Application for a non-material amendment following a grant of planning permission. Town and Country Planning Act 1990

Replacement of existing single storey garage and out buildings with single storey side extension and two storey rear extension - Amendment following FG/178/16/HH

FG/122/17/HH

GROUND FLOOR PLAN

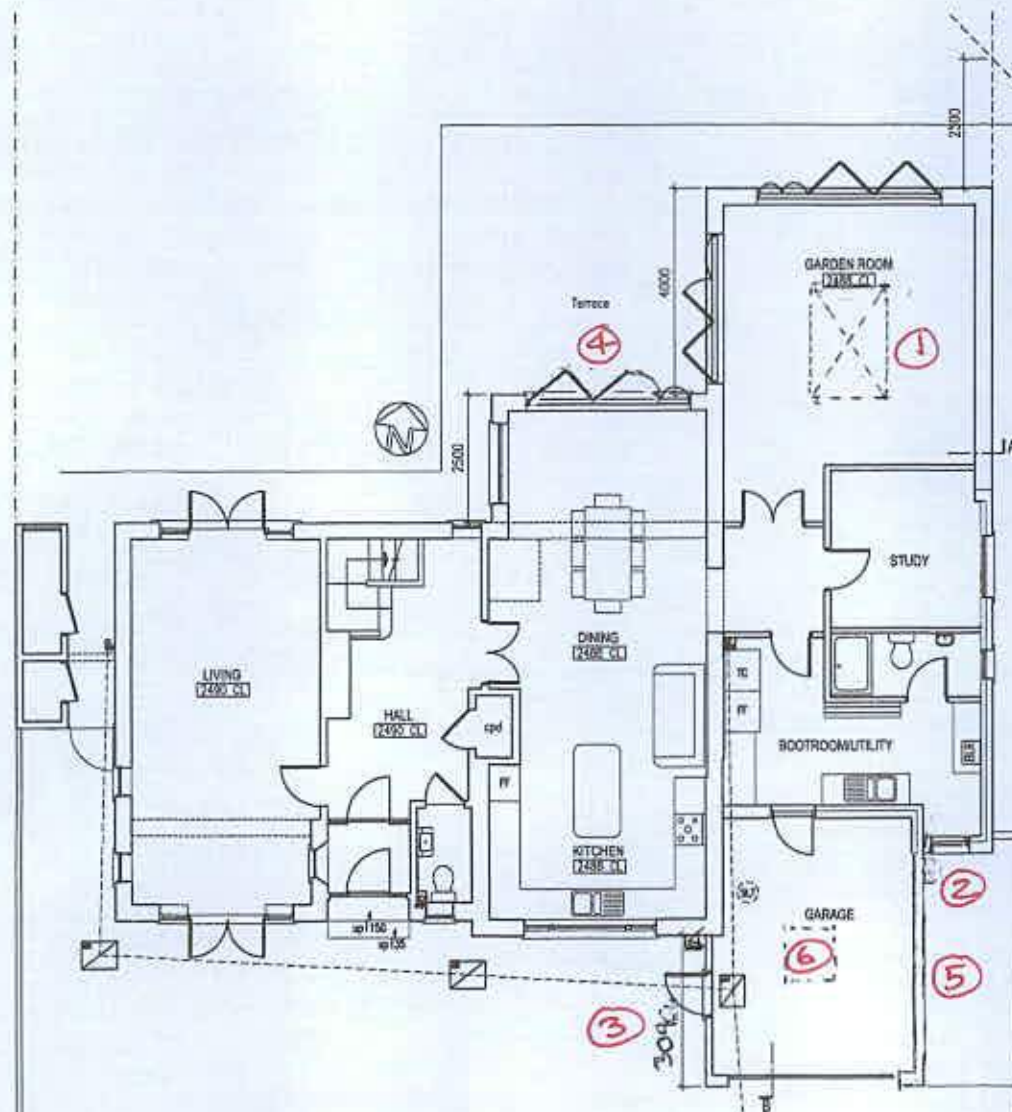
- 1 - Rectangular lantern in garden room instead of a square one
- 2 - Window to utility room instead of a door.
- 3 - Forward projection of garage from house as built is 3090.
- 4 - Height of garage changed. Now 2900 to top of coping on parapet to GL/FFL at garage door
- 5 - Removal of 2 window openings in garage wall
- 6 - New 1m sq roof light in garage
- 7 - 3 panes in bifold instead of 4 in dining room
- 8 - Bedroom window slightly wider and 2 opening lights

- 1 - more light in room as faces north
- 2 - to provide more room for worktops door not required as garage side door
- 3 - as built.
- 4 - Parapet provides an attractive feature rather than a flat roof
- 5 - been asked to by planning
- 6 - light source instead of windows
- 7 - so all panes open together and aesthetical
- 8 - more light as north facing and better ventilation
